**KIRKLEES METROPOLITAN COUNCIL  
INVESTMENT & REGENERATION SERVICE**

**DELEGATED DECISION TO DETERMINE PLANNING APPLICATIONS**

Reference No:	<b>2025/62/91627/W</b>
Site Address:	42A, Station Road, Fenay Bridge, Huddersfield, HD8 0AD
Description:	Erection of two storey extension to side and front, balcony to rear and associated external alterations
Recommending Officer:	Joanna Rednall

**DECISION – REFUSED**

Proposed Elevations

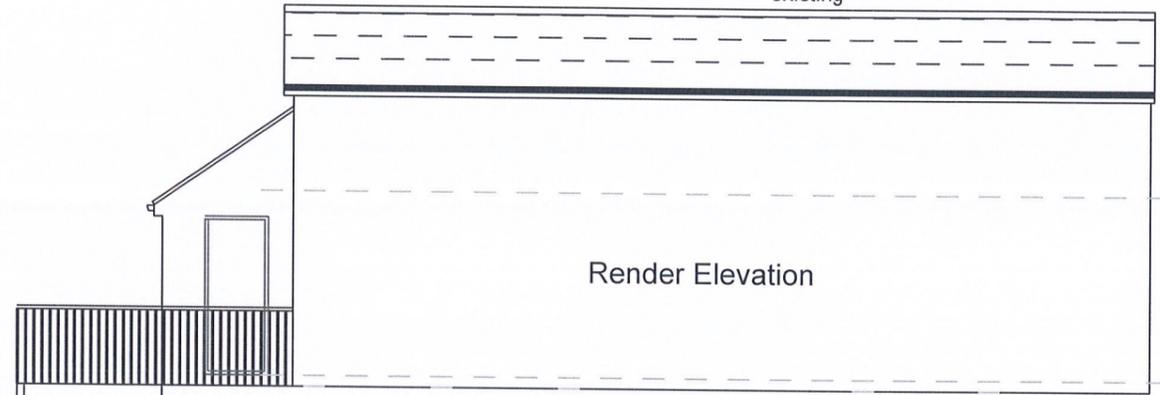
The proposed extension projects approximately 6 metres from the side elevation of the host dwelling and extends forward of the principal elevation, forming a two-storey addition. It continues the existing eaves and ridge height of the original property and is not set down, resulting in a substantial and visually bulky form when viewed from the front, particularly on approach from Station Road. The combination of the significant forward projection and two storey height creates an extension that is neither subservient nor proportionate to the original dwelling. This impact is further heightened by the original dwelling's single-storey scale when viewed from this aspect. As such, the proposal would result in an overly dominant and incongruous addition that fails to respect the scale, form, and character of the host property. As such, the extension is considered to have an unacceptable impact on visual amenity and would be contrary to the aims of Policy LP24 (a and c) of the Kirklees Local Plan.

Although the dwelling is set back from Station Road and is not overly prominent from this viewpoint, the sloping nature of the surrounding landscape results in it being clearly visible from public vantage points to the west. While the front elevation is located in a more discreet position, this would not overcome the harm the proposed development would cause to the character of the original dwelling or its impact on the wider street scene when viewed from the rear.

The proposed extension would be finished in a variety of materials including coursed stone, render, composite cladding with a tiled roof to match the host dwelling. There is a mixed material palette surrounding the site comprising brick, stone, and render, with the application property finished in coursed stone. The cladding would introduce a material which is not common within the vicinity and its prominent location would intensify the visual impact. This, combined with the large scale of the extension, would form an incongruous addition which

would be inharmonious with the host property, forming an unsympathetic feature and contrary to the aims of LP24c.

Taking into account all the above, it is considered that the proposal would not be a subservient addition to the host property and by virtue of its location, design, scale and massing, would cause detrimental harm to the host property and wider locality. The proposal is therefore not considered to comply with the policies within Chapter 12 of the NPPF, LP24 of the Kirklees Local Plan or Key Design Principles 1 and 2 of the House Extensions and Alterations SPD.

Site Plan & Roof Plan		
Fenay Bridge		
HD8 0AD		
Date	May 2025	Dwg no 05
Scale	A3 - 1:200	
Dwn By	-----

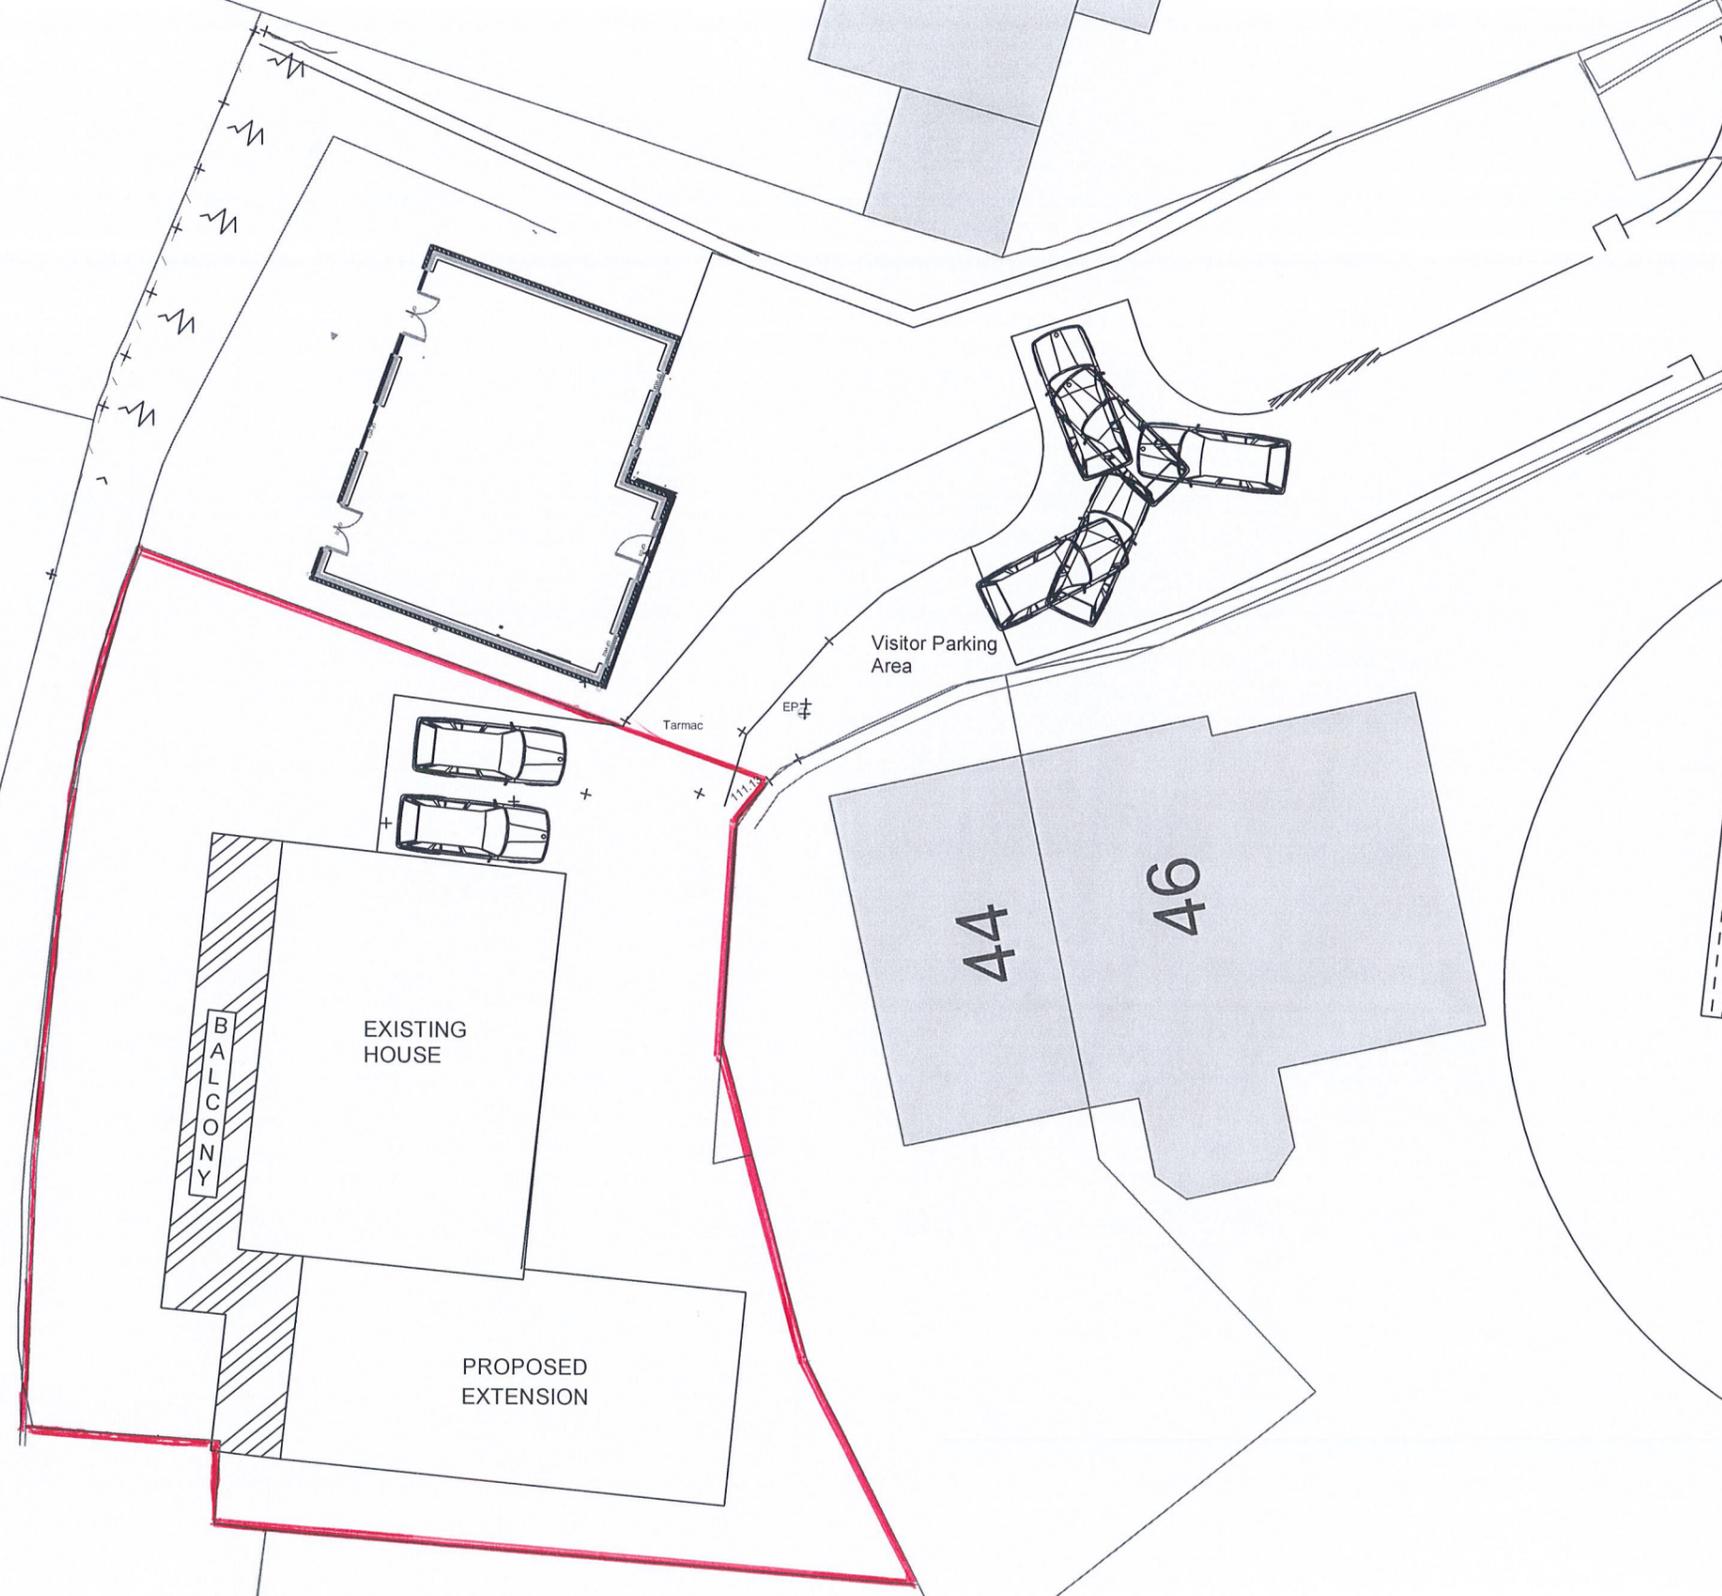
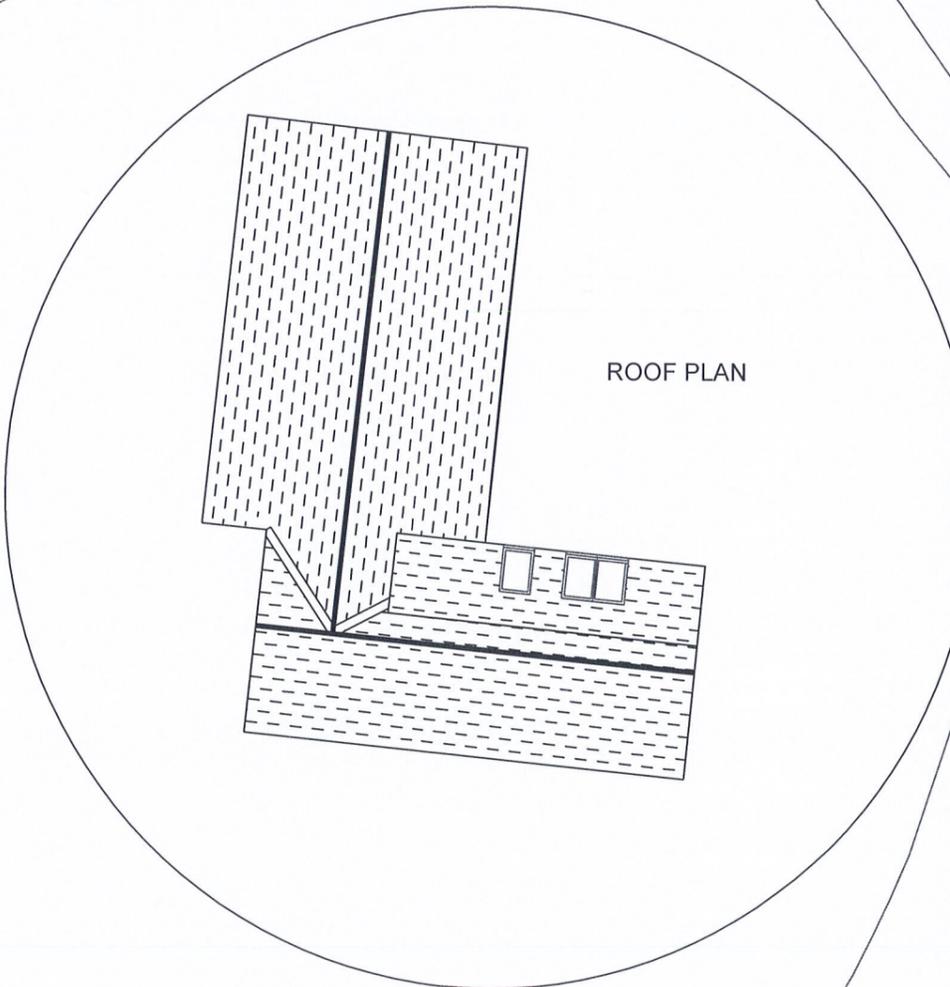
A balcony is proposed on the west-facing elevation, extending across both the existing building and the proposed extension. Due to its position, the balcony would be prominent when viewed from the west and visible from broader public vantage points within the valley. However, its modest scale and use of lightweight materials to the rear would help it maintain a visually unobtrusive and lightweight appearance, preventing it from appearing incongruous in the wider landscape. At ground level, existing west-facing openings would be enlarged to accommodate two sets of sliding doors. These alterations are considered to have minimal visual impact and are therefore considered to be acceptable in terms of visual amenity.
